Item No.	Report of the Head of Development Management and Building Control	
Address:	49 GLEDWOOD AVENUE HAYES	
Development:	Change of use from Class C3 Dwellinghouse to 6-bed 6-persons Class C4 HMO with no external alterations.	
LBH Ref Nos:	64670/APP/2026/249	
Drawing Nos:	Design and access statement 2026-49GA-PL-1 2026-49GA-PL-2 Design and access statement Validation checklist HMO Management Supervision Plan SITE SUPERVISION MANAGEMENT PLAN	
Date Plans received:	28-01-26	Date(s) of Amendments(s):
Date Application valid	28-01-26

The application seeks planning permission for a change of use from C3 dwellinghouse to 6 bed, 6 person C4 HMO.

PROPOSED SITE PLAN (1:500)

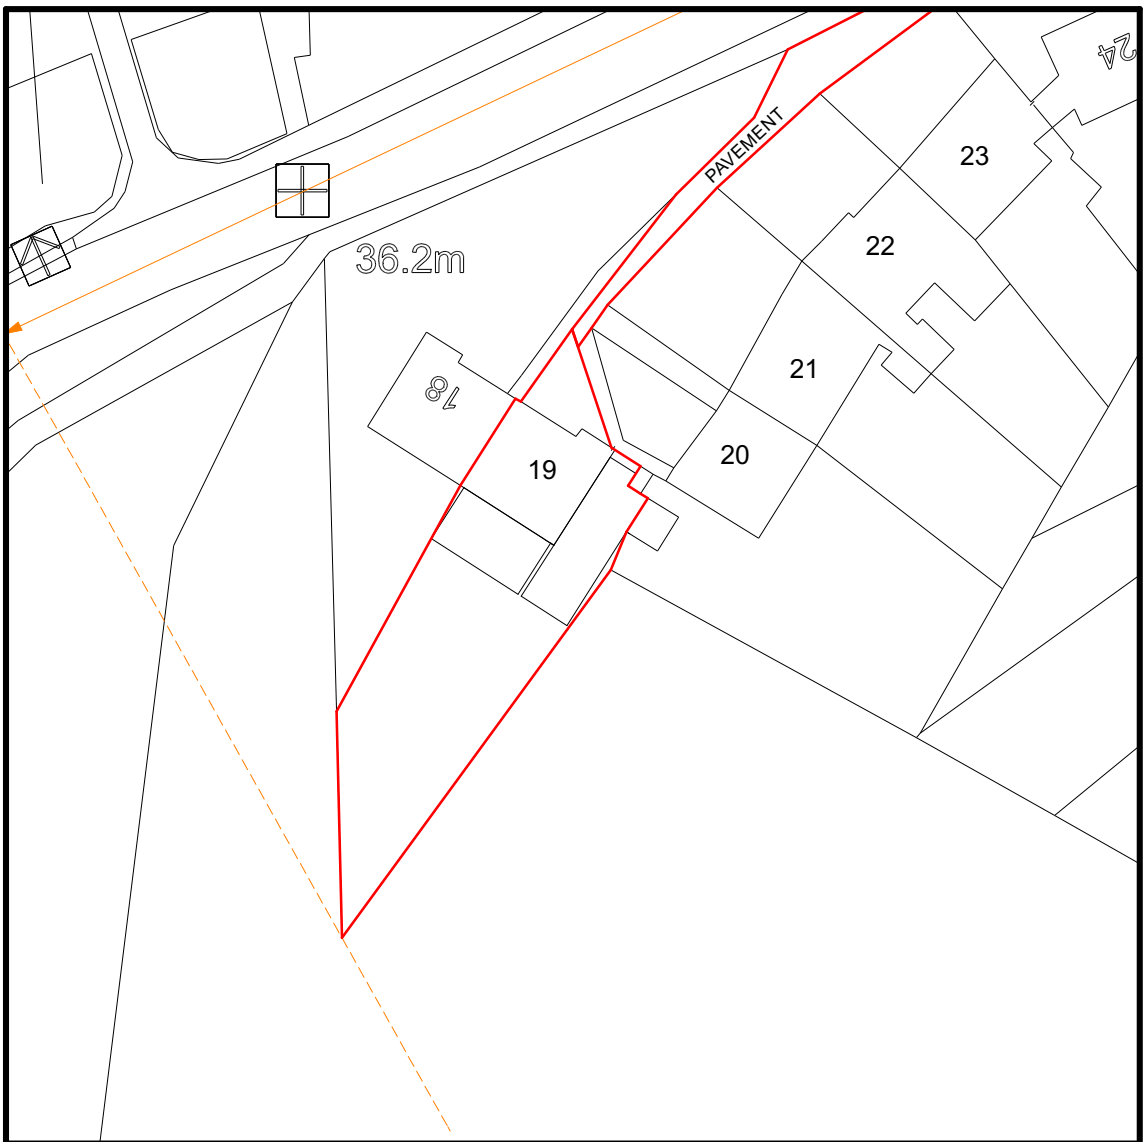
For a six person HMO, Local Plan standards require 3 on site parking spaces and 6 cycle parking spaces. The proposed development will have 1 onsite car parking space. Therefore, given the requirement for 3 on site parking spaces, the proposal results in a net shortfall that would displace parking demand for 2 vehicles onto the uncontrolled public highway.

PROPOSED G/F (1:100)

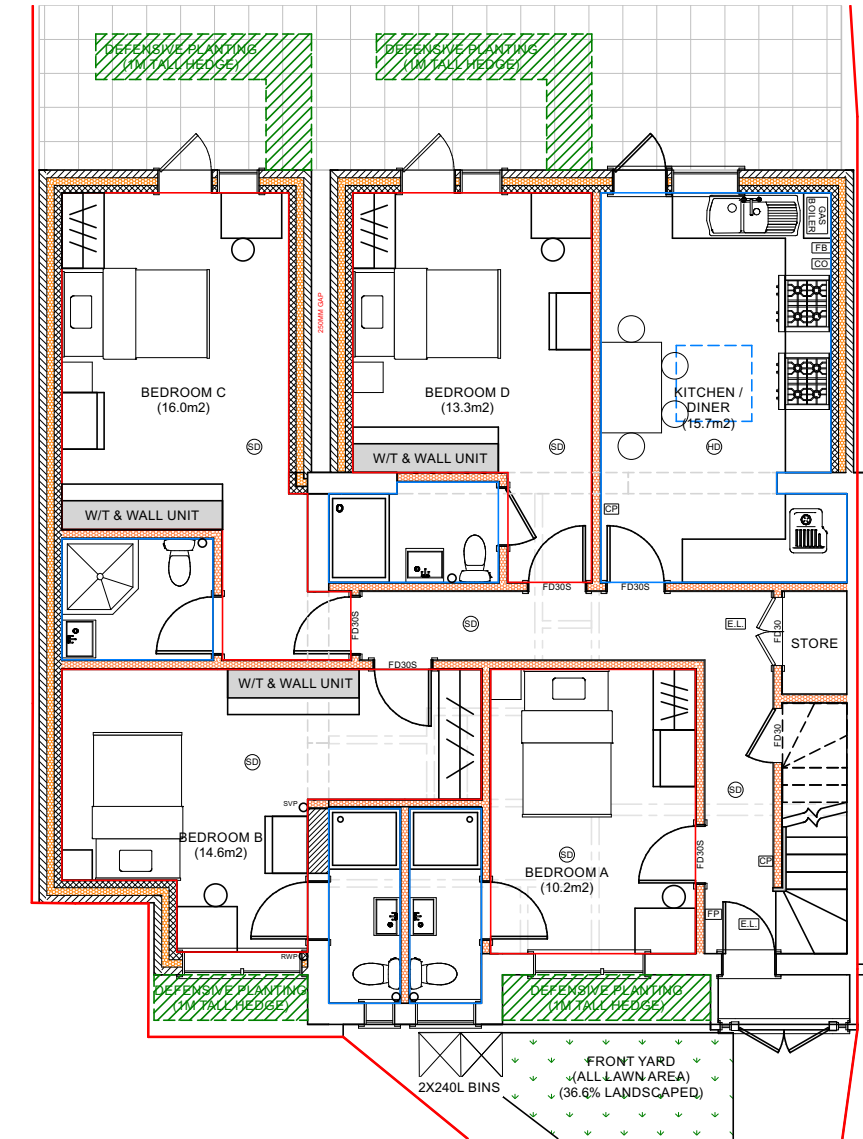
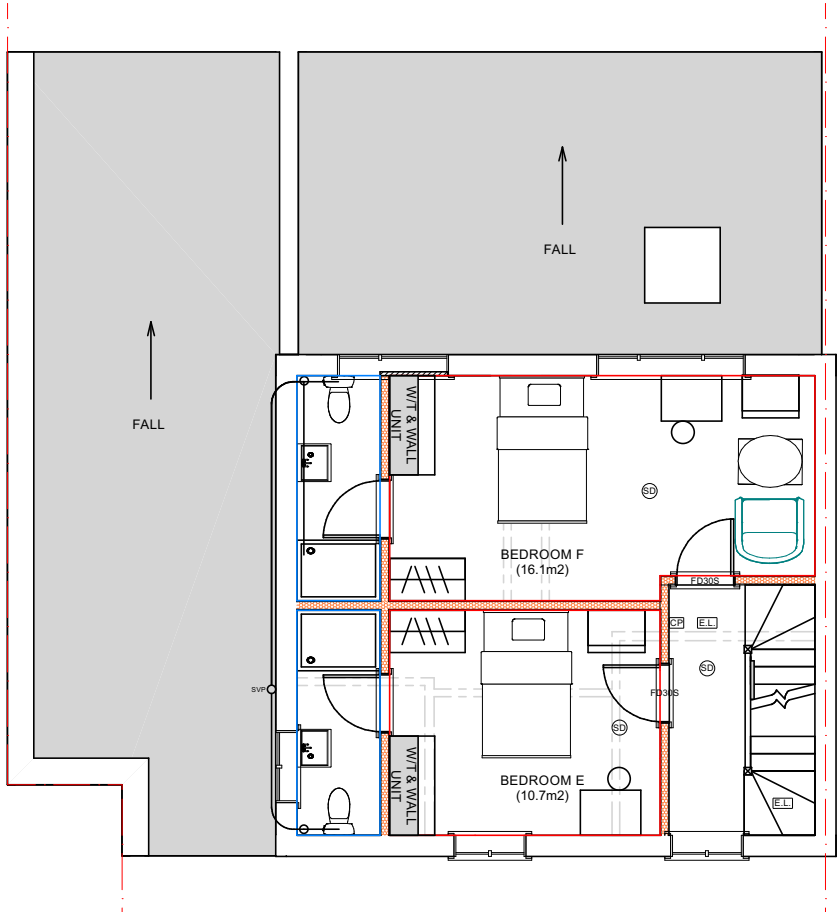
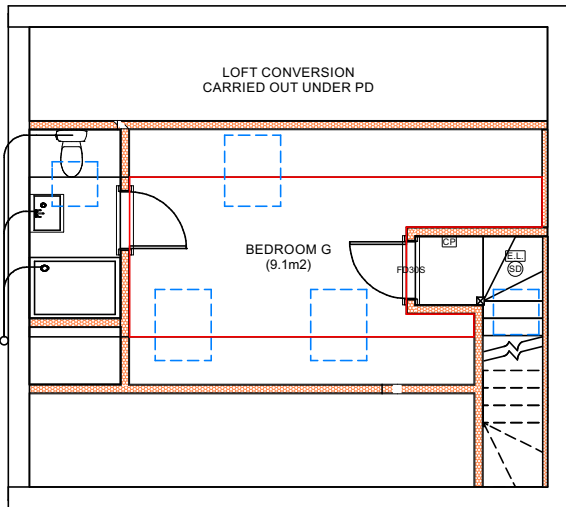
The proposed 6 bedroom HMO would fail to provide an acceptable standard of internal living accommodation for future occupiers. Bedrooms 2 and 3 would suffer from an unacceptable loss of privacy and amenity due to its proximity to the sole communal space and both bedrooms would not achieve any outlook given the obscure glazing of the rear facing windows and doors. The sole communal kitchen/dining space also receives limited light and outlook. As a result, the development would not deliver appropriate outlook or residential amenity, contrary to Policies D3 and D6 of the London Plan (2021), Policies DMH 5 and DMHB 16 of the Hillingdon Local Plan: Part 2 (2020), and Paragraph 135(f) of the National Planning Policy Framework (2024).

The bedrooms would provide adequate space for single occupancy, and the size of the communal living room is considered acceptable in quantitative terms. However, significant qualitative concerns are raised in terms of the quality of the bedrooms 2 and 3 to the rear which have no outlook. Both bedrooms are served by a rear facing window and door which are obscure glazed. This would provide a very poor living environment to future occupiers of these rooms. The only communal space is also served by a single side facing window which looks over the shared driveway to the flank wall of the neighbouring property. The levels of light and outlook to this habitable space are therefore poor. Access to rooms 2 and 3 is also directly off the communal kitchen with residents being affected by the noise and disturbance associated with the only communal space.

This relationship represents a clear conflict with Policy D3 of the London Plan, which requires appropriate privacy and a comfortable living environment, and Policy DMH 5, which requires satisfactory living conditions for HMO residents. The qualitative harm arising here is substantial and cannot be mitigated through layout alone.

PROPOSED REAR GARDEN
WITH SOFT AND HARD
LANDSCAPING

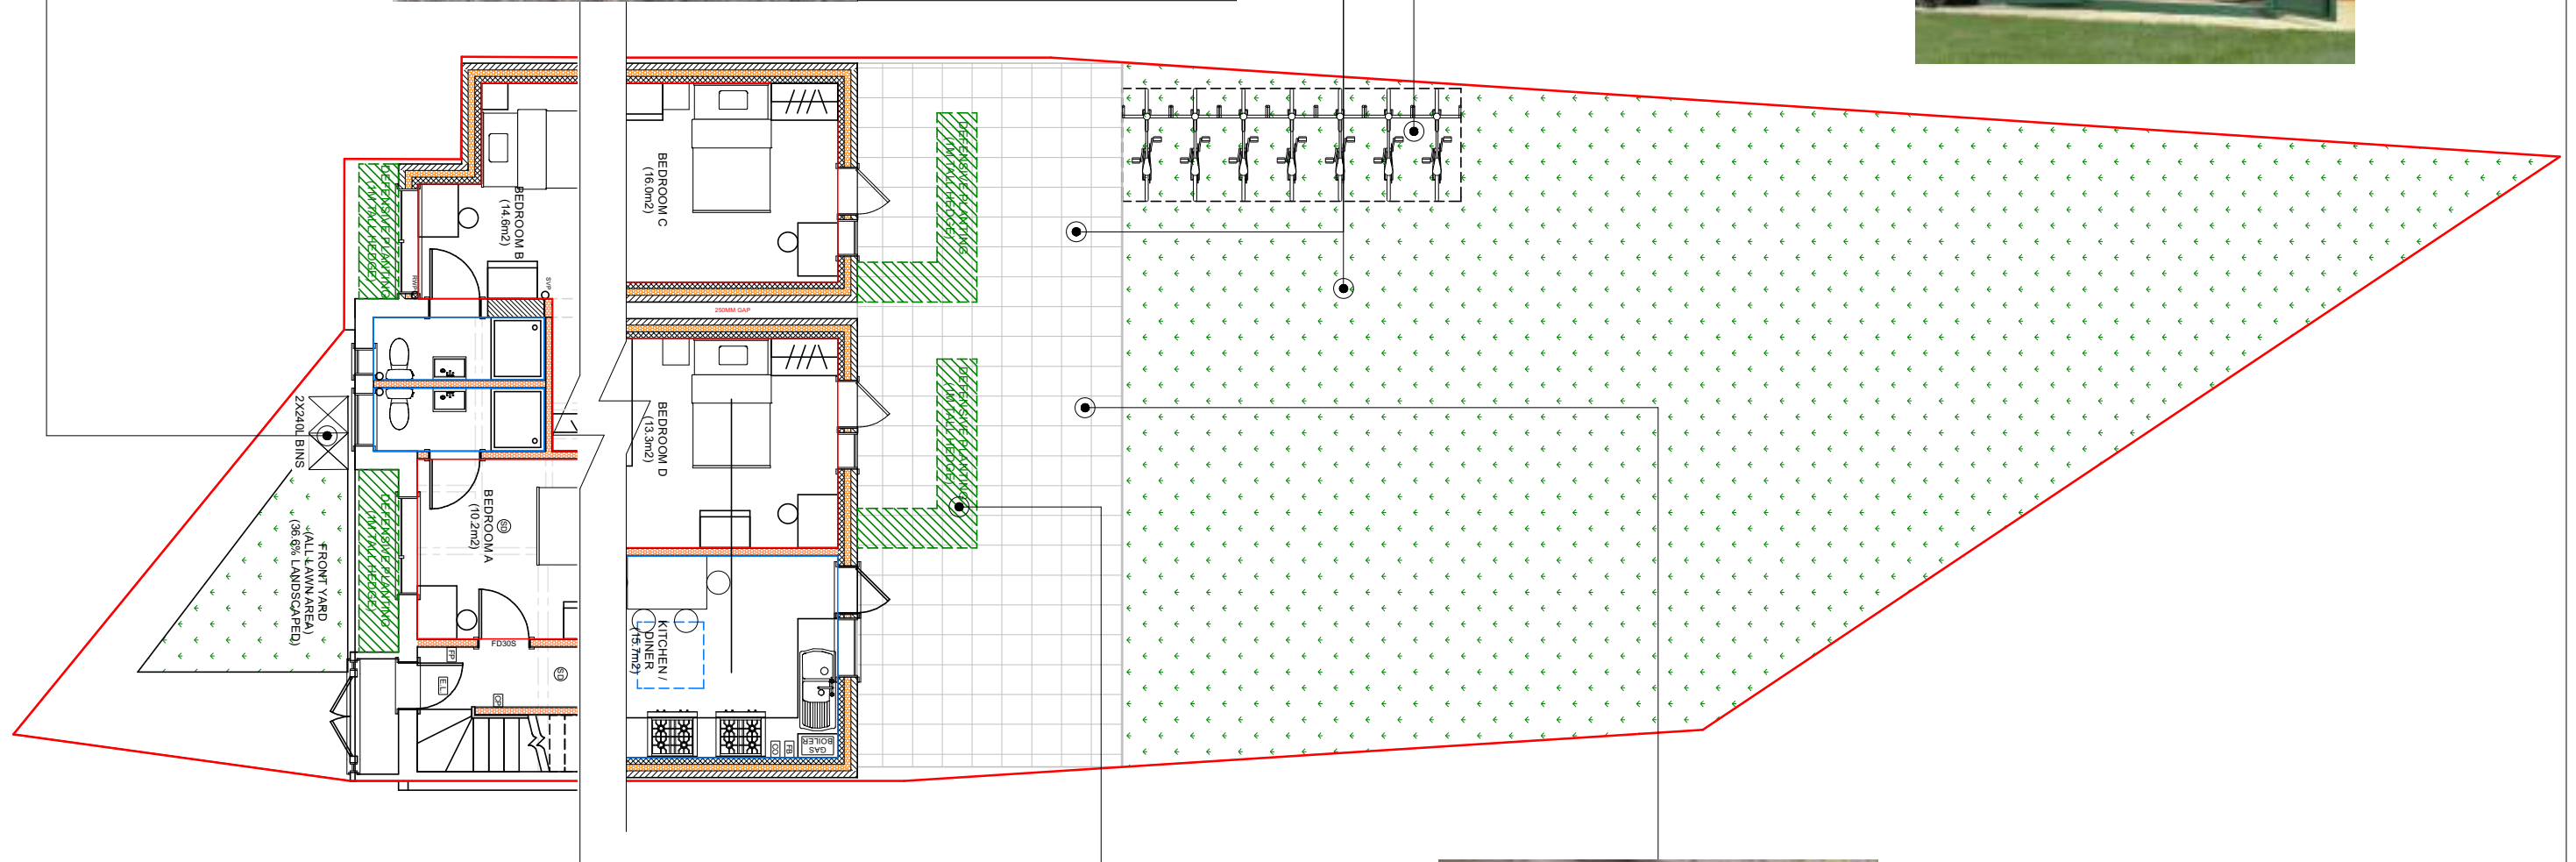
Highway impacts are also unacceptable. Only one off-street parking space is provided where three are required, likely resulting in overspill parking and associated highway safety concerns in a PTAL 1b area. The proposed vertical cycle storage fails to meet London Cycle Design Standards.

The submitted plans indicate the provision of 6 secure cycle spaces to be located within the rear garden. However, no detailed plans or specifications have been provided to demonstrate this. The side access, measured at approximately 0.85m within the red line boundary, falls significantly below the minimum 1.2m clear width required by the London Plan, the London Cycling Design Standards, and LTN 1/20 to allow a user to walk alongside and manoeuvre a cycle safely.
